Yorkshire Water Services
Developer Services
Pre-Development Team
PO BOX 52
Bradford
BD3 7AY

Your Ref: 2024/93156
Our Ref: A005875

Healey Lane Mills, Healey Lane, Healey, Batley - Outline application for redevelopment of existing Islamic Centre

Drainage Strategy

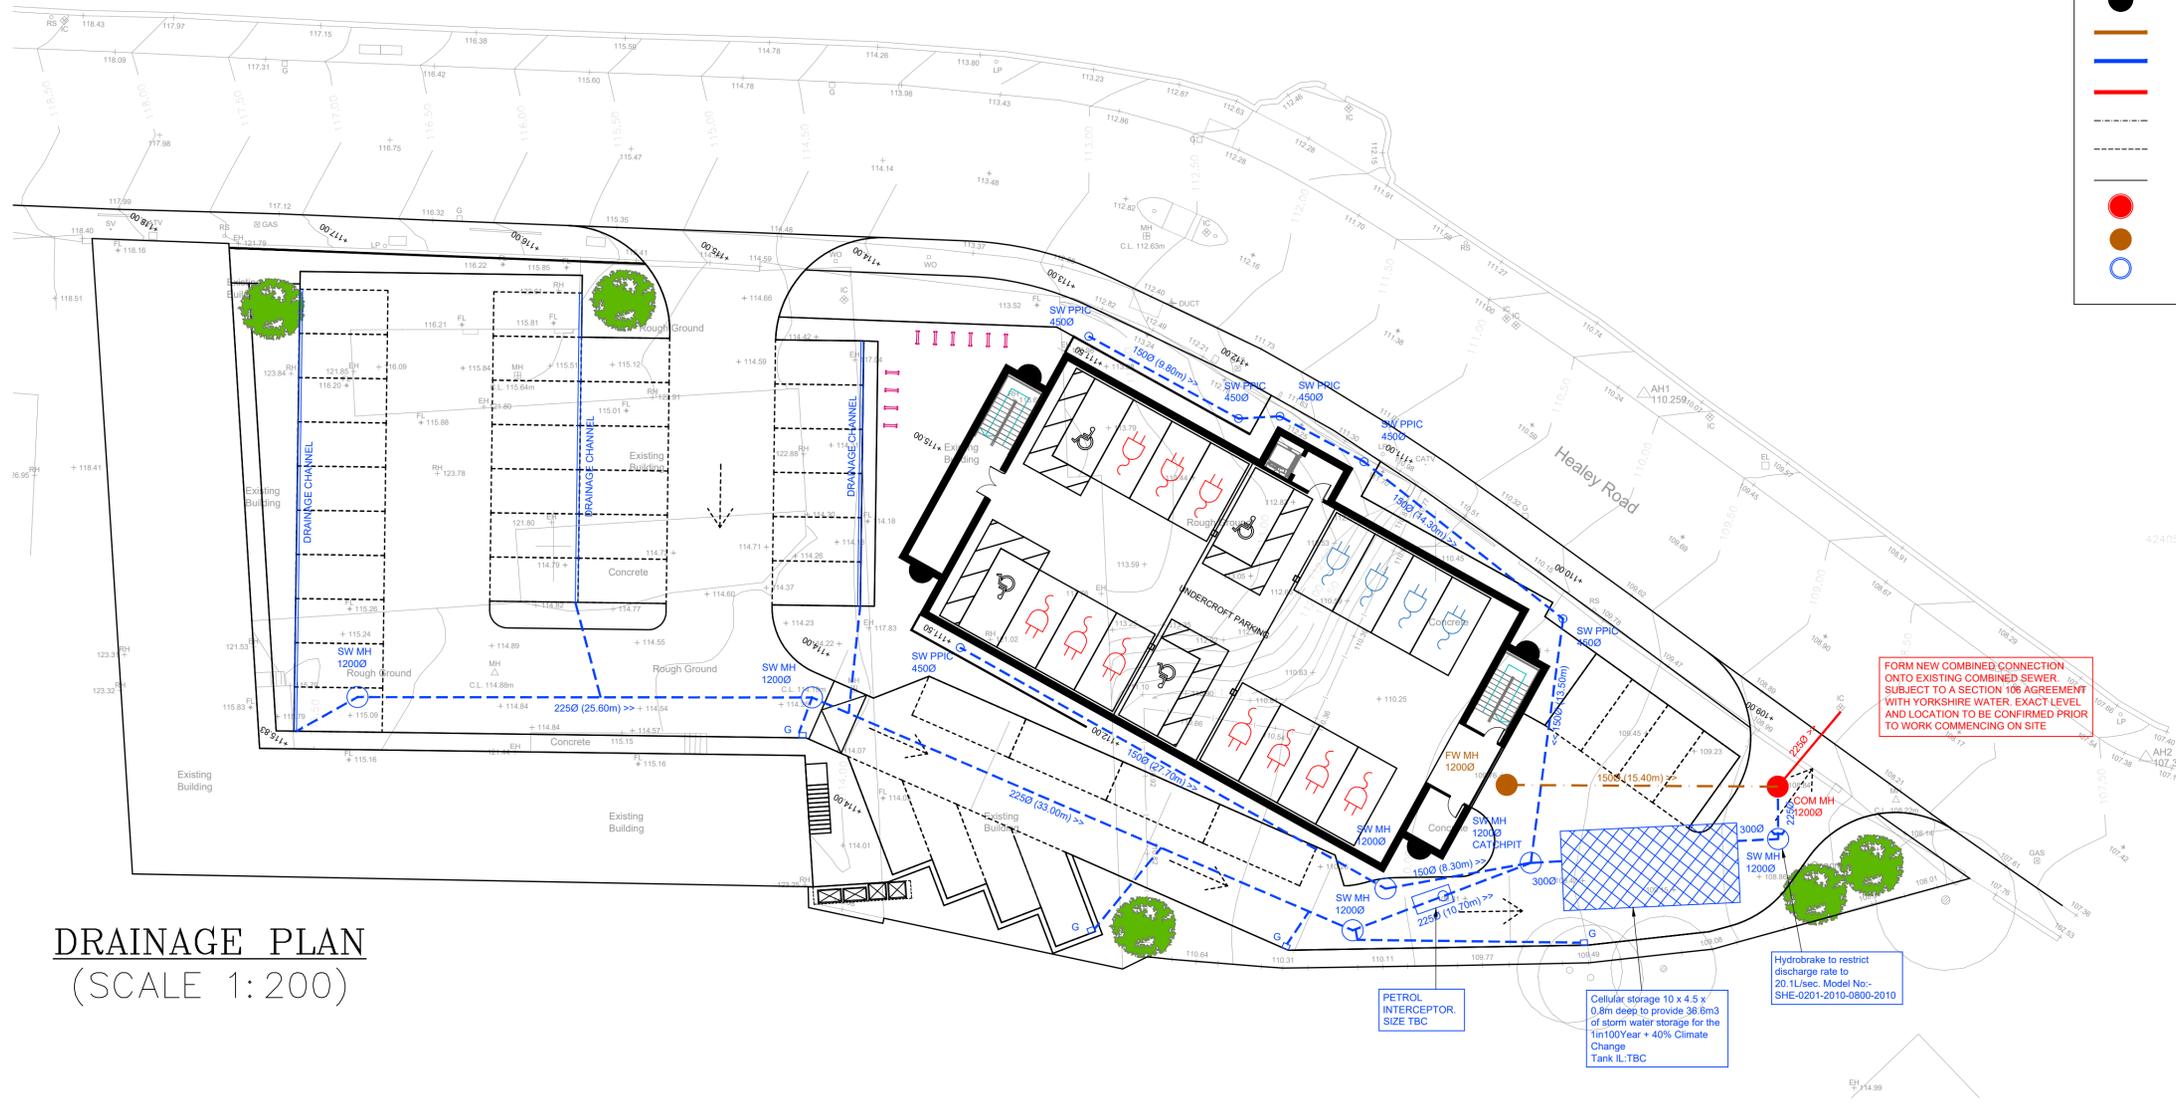
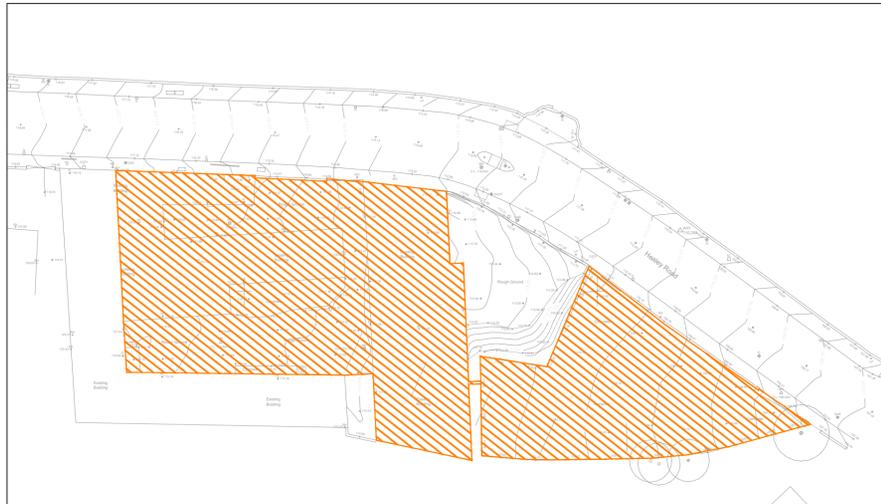
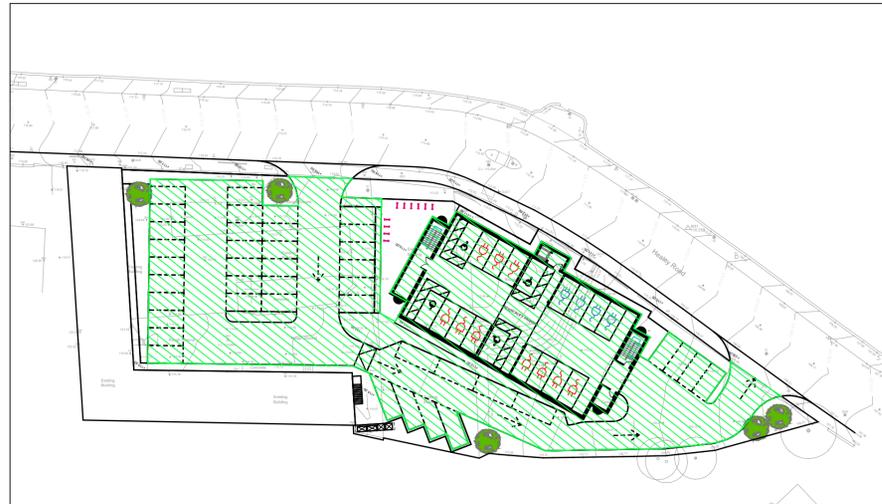
1. The drainage details submitted on drawing, Drainage Strategy 580/D01 (revision P1) dated 12/07/2024 prepared by Krypton Structures require amendments, but if planning permission is granted, the matter can be dealt with via condition. The following points should be addressed:

- i) evidence should be submitted to show that other (than discharge to public sewer) means of surface water disposal have been considered and why they have been discounted.
- ii) evidence of existing impermeable areas positively draining to the public sewer is required to prove rate of discharge.

3. The developer is proposing to discharge surface water to public sewer however, sustainable development requires appropriate surface water disposal. Yorkshire Water promote the surface water disposal hierarchy and the developer must provide evidence to demonstrate that surface water disposal via infiltration or watercourse are not reasonably practical before considering disposal to public sewer.

Only as a last resort, and upon receipt of satisfactory evidence to confirm the reasons for rejection of other methods of surface water disposal, curtilage surface water may discharge to public *surface water* sewer. Surface water discharges to the public sewer must have a minimum of 30% reduction based on the existing peak discharge rate during a 1 in 1 year storm event.

The developer will be required to provide evidence of existing positive drainage to a public sewer from the site to the satisfaction of Yorkshire Water and the Local Planning Authority by means of physical investigation. On-site attenuation, taking into account climate change, will be required before any discharge to the public sewer network is permitted.
